DEPARTMENT OF PUBLIC WORKS

County Survey review of Boundary Line Adjustment 16-00014 (Mitchell)

**PART OF THE NORTHWEST QUARTER OF SECTION 33,  
TOWNSHIP 18 NORTH, RANGE 19 EAST, W.M.**

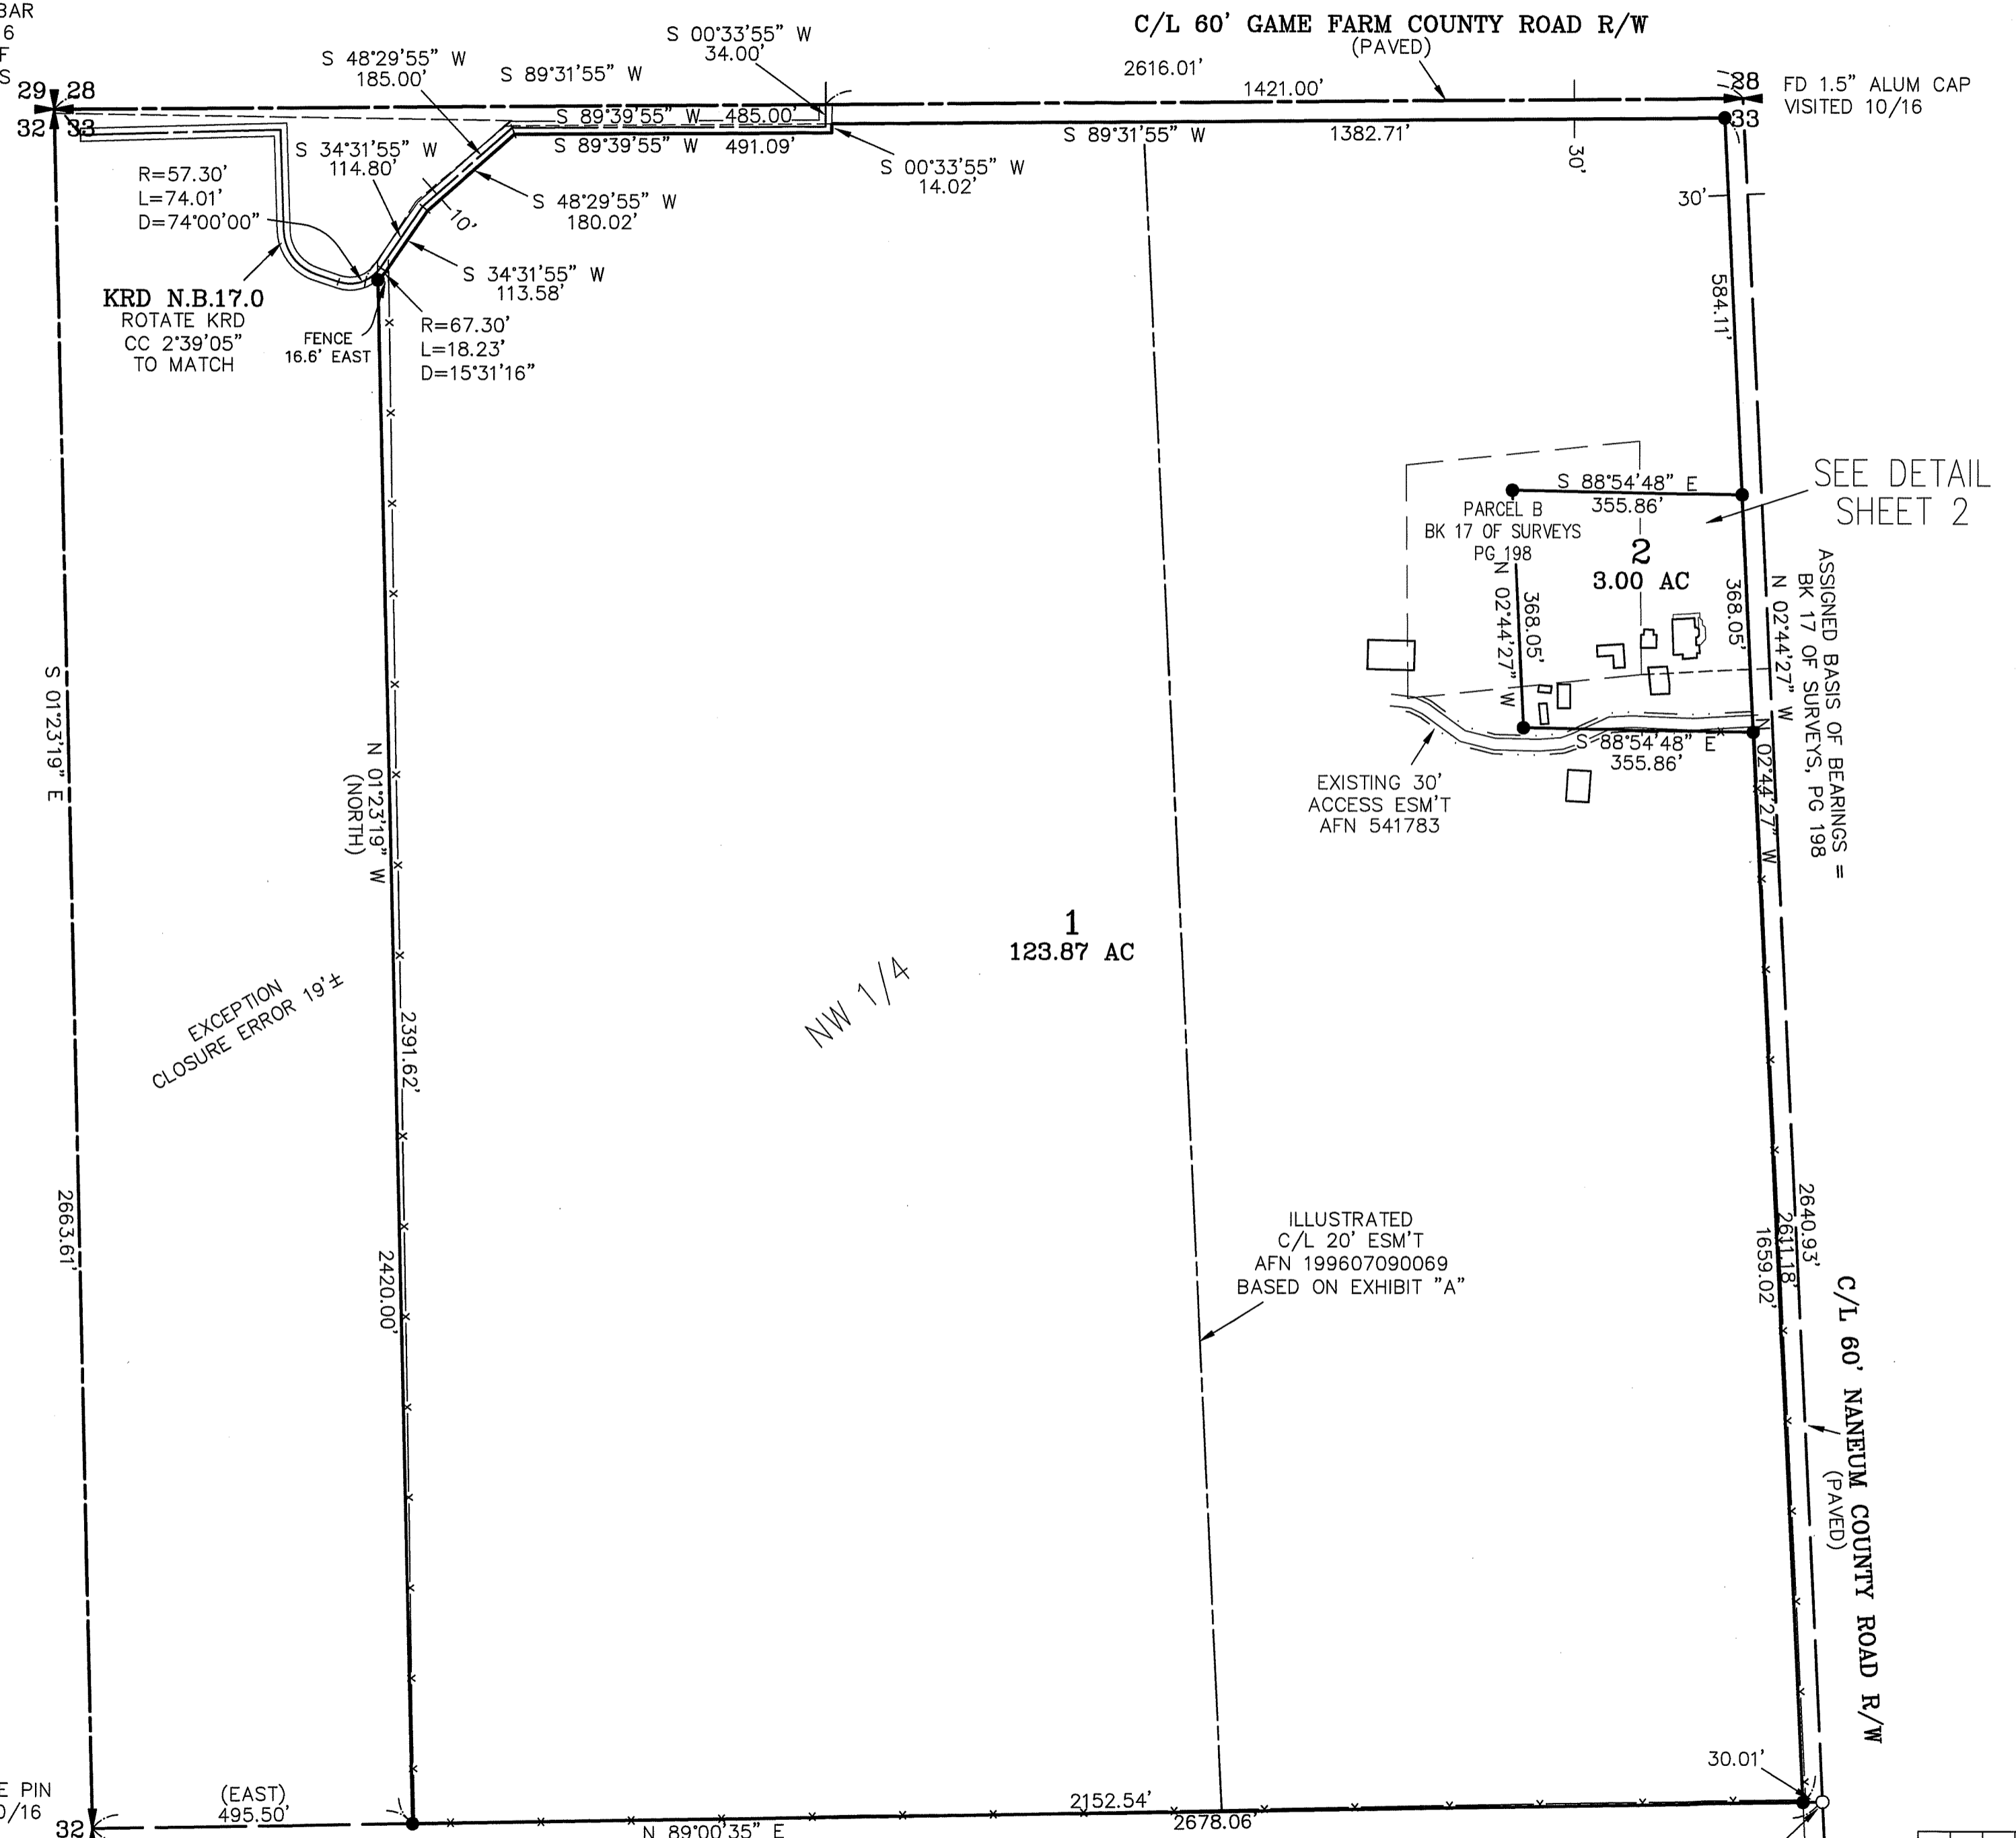
1. Sheets that show Game Farm Rd or Naneum Road., should include the road name, ownership (County R/W), width, and surfacing material.
2. Dimension the distance between the fenceline and the Property line at the NW corner of the property.
3. Provide the document Number creating or referencing the existing 30' access easement OR if none exist, and the easement is by prescription, please state such.
